Application No: K/52/20/HH
Site Address: Flint Barn Peak Lane Kingston Gorse BN16 1RN
Description of works: Single storey front extension, first floor front/side extension, first floor rear extension and conversion of roofspace to habitable use to include a juliette balcony.

Thank you for your internet representation made on 11th January 2021 which has been recorded as no objection with the comments as follows:

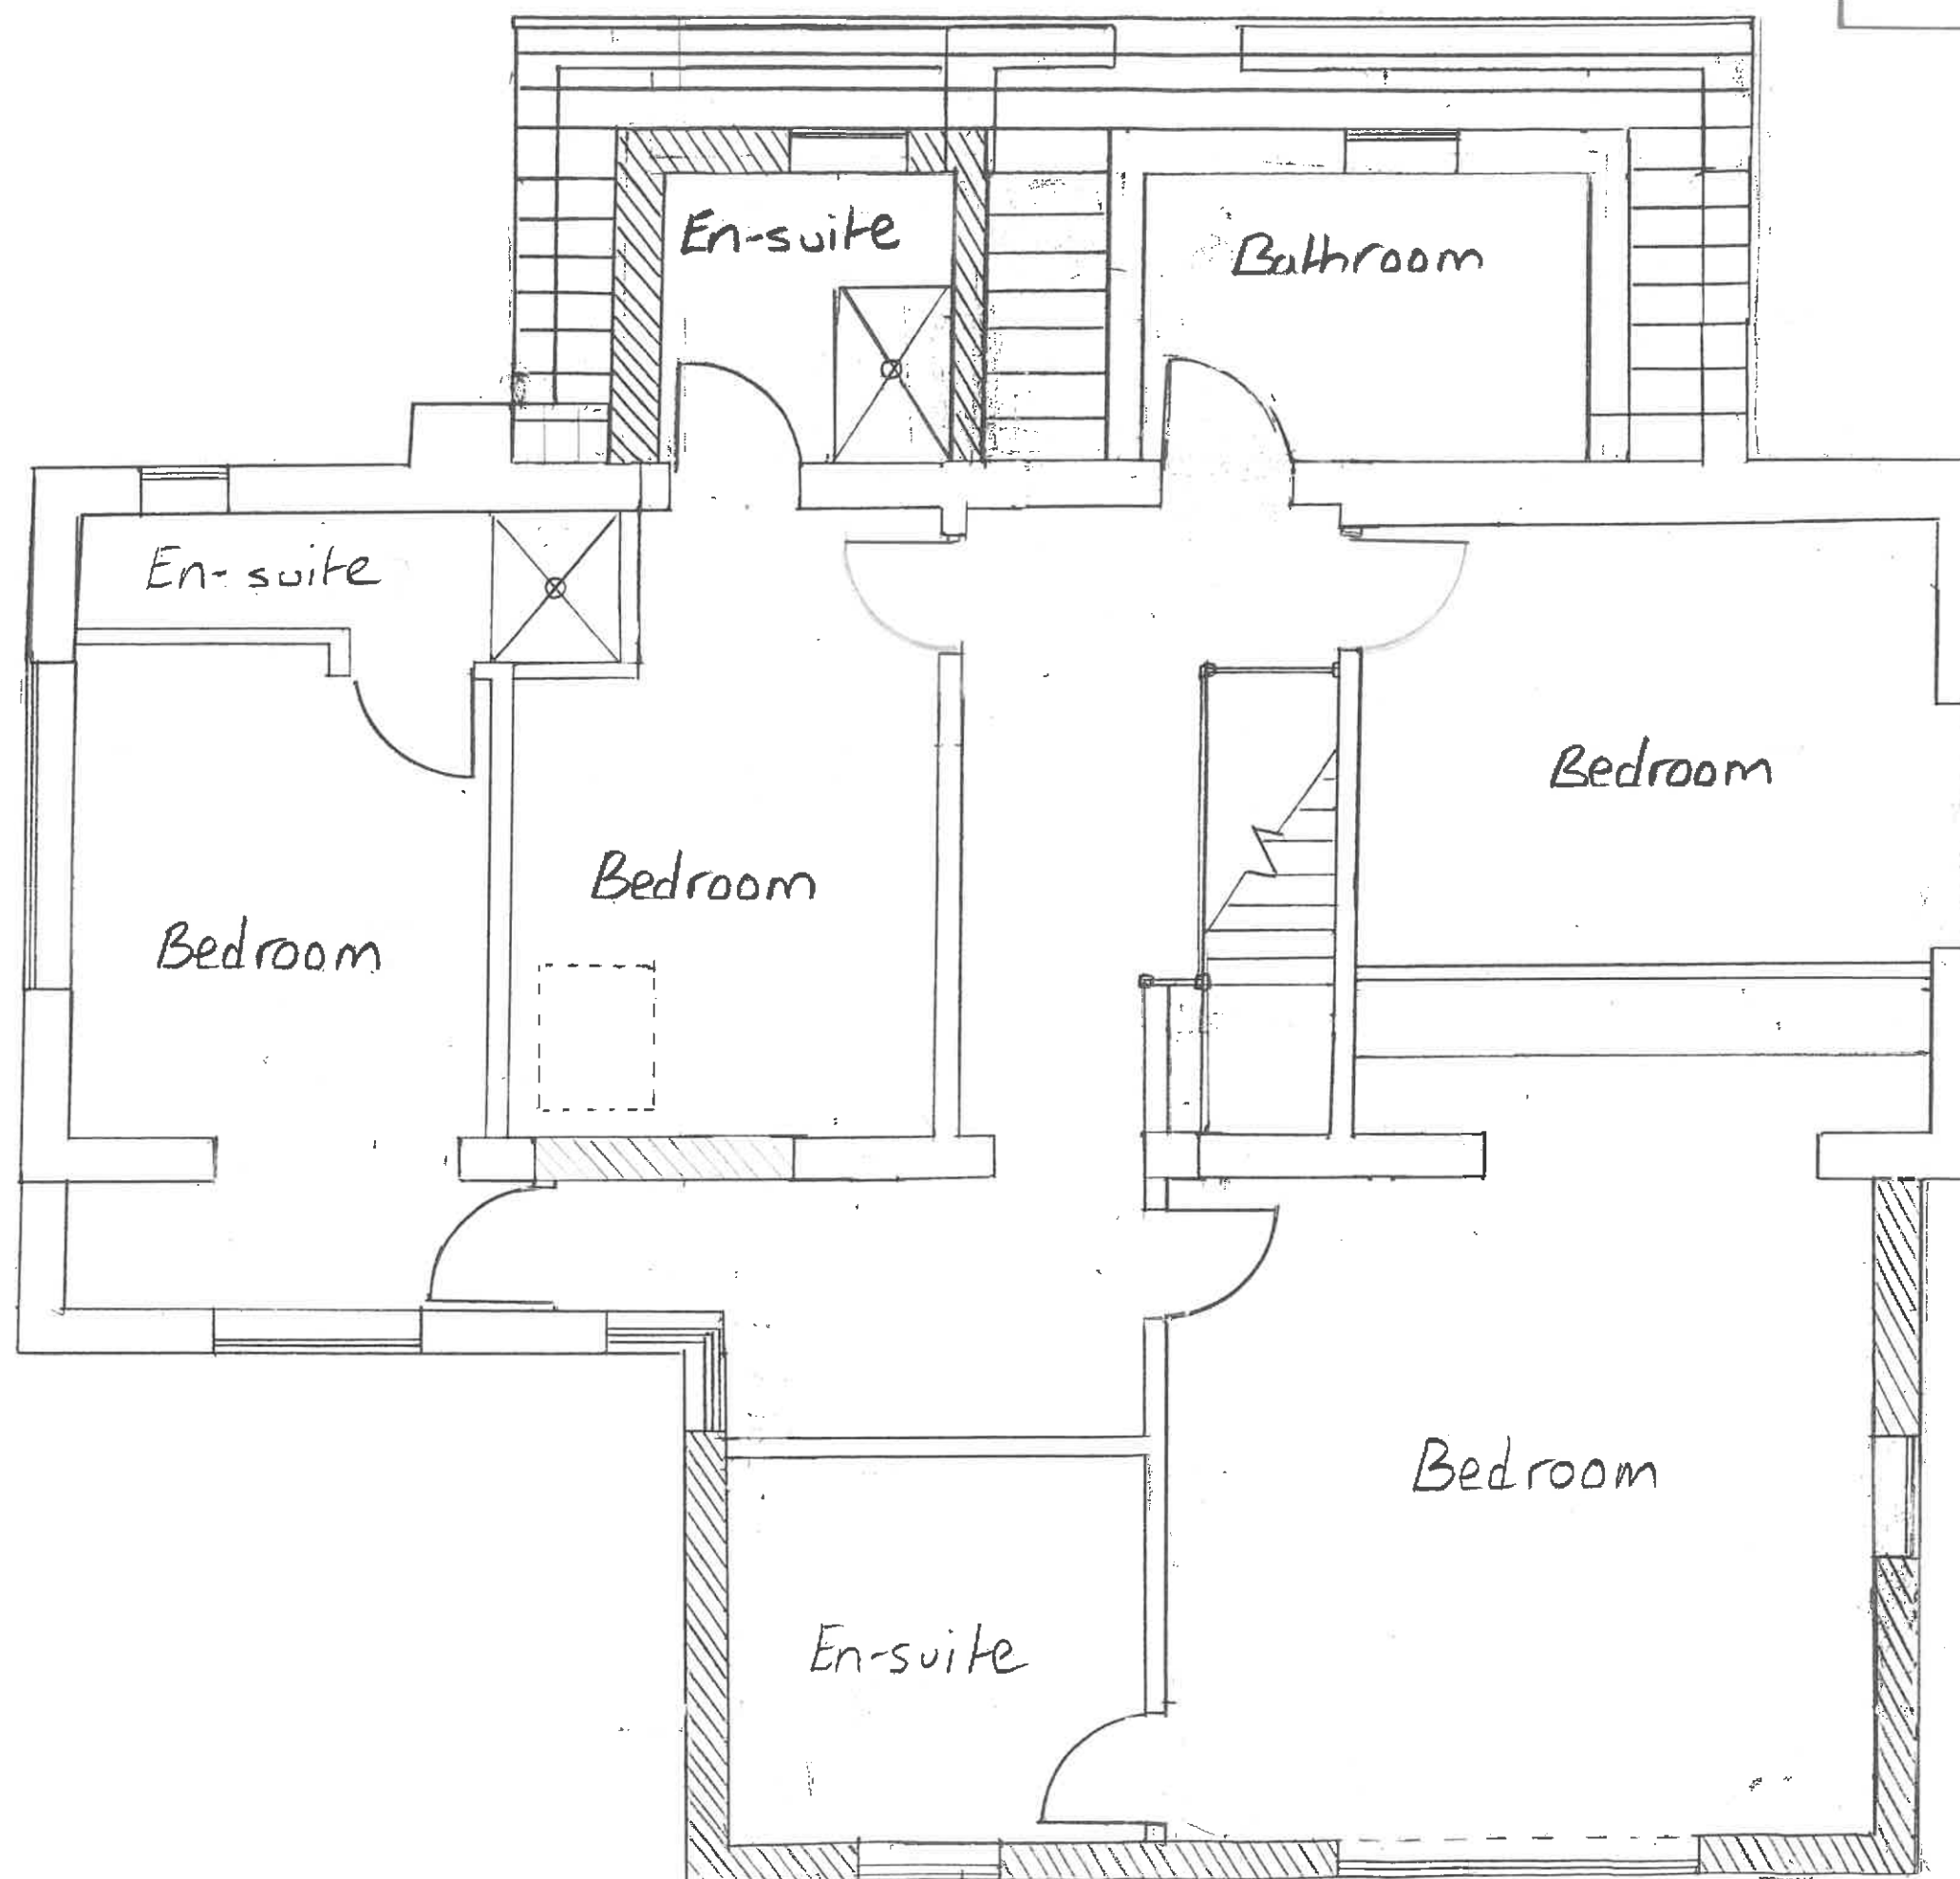
- The plans have a discrepancy: the first floor and roof plans show one dormer with two skylights that does not match the north elevation which shows two separate dormers.
